From: [Jared Romero](#)
To: [Derek Bohannon](#)
Cc: [Ron Bohannon](#); [Chen, Tiequan](#); [Martinez, Richard](#); [Hughes, James D.](#); [Nicole M. Friedt](#); [Montoya, Anthony](#)
Subject: Re: [#2023004] 10088 Coors NW - 7 Bar Retail - AMAFCA Comments
Date: Monday, March 24, 2025 10:02:25 AM
Attachments: [image001.png](#)
[image.png](#)
[image.png](#)
[image.png](#)
[image.png](#)
[AMAFCA General Construction Notes and Requirements 11-2024 FOR OTHER PROJECTS.doc](#)

Below are AMAFCA's comments on the plans dated March 2025 for the 7-Bar Retail Project. Please provide a comment disposition sheet with the resubmittal detailing how each comment below is addressed or acknowledged.

EROSION CONTROL PLAN

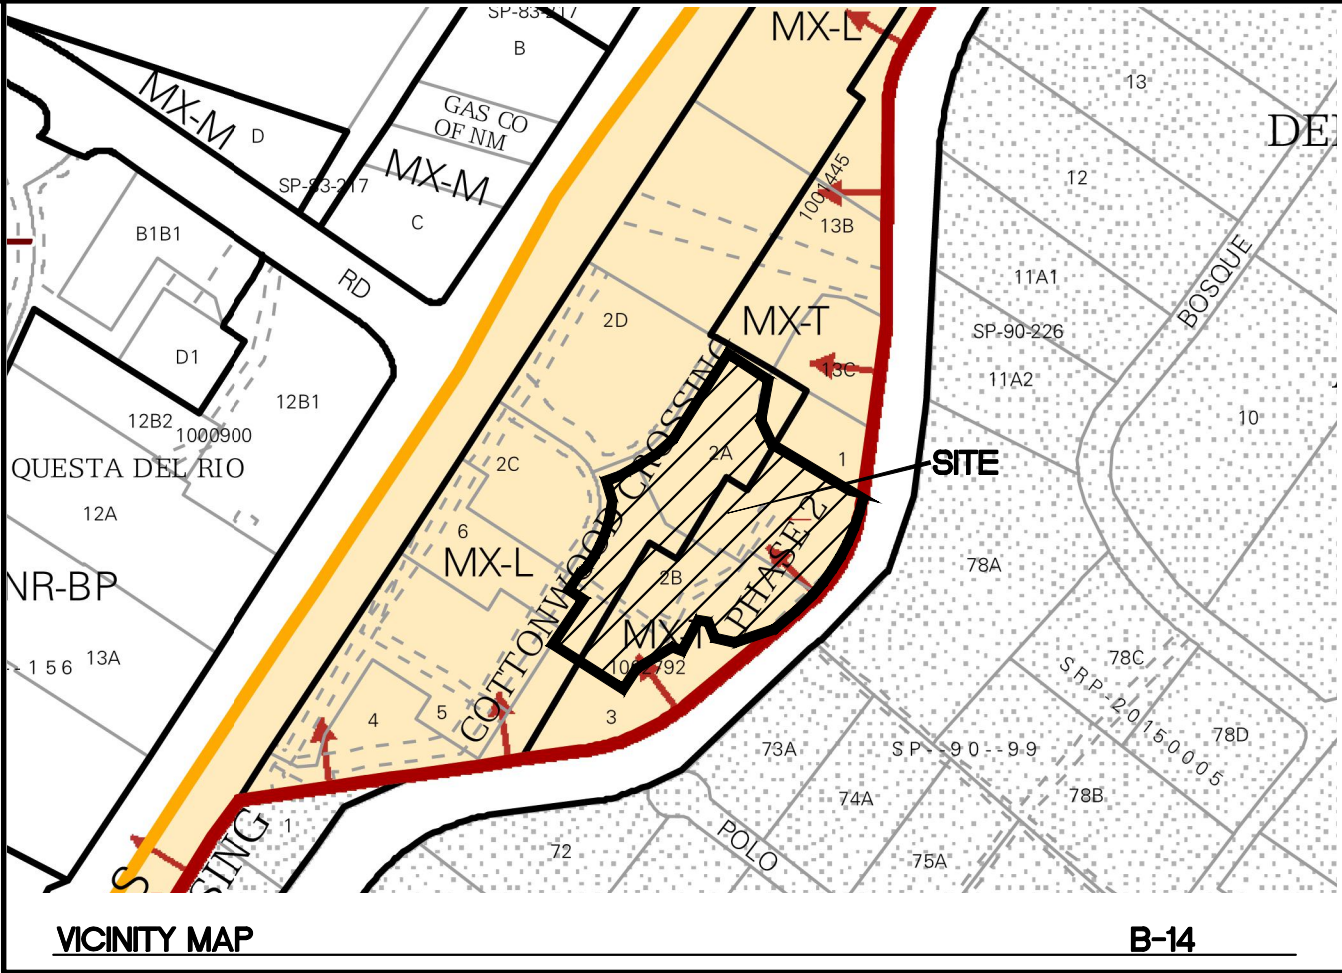
- There isn't an erosion and sediment control plan in this plan set, but any erosion and sediment control plan for this site must not allow any construction stormwater discharge into AMAFCA's facility(ies). Any debris/sediment that accumulates in AMAFCA's facility as a result of construction discharge will be considered a unpermitted discharge and will be required to be remediated to AMAFCA's satisfaction at the cost of the owner/contractor.
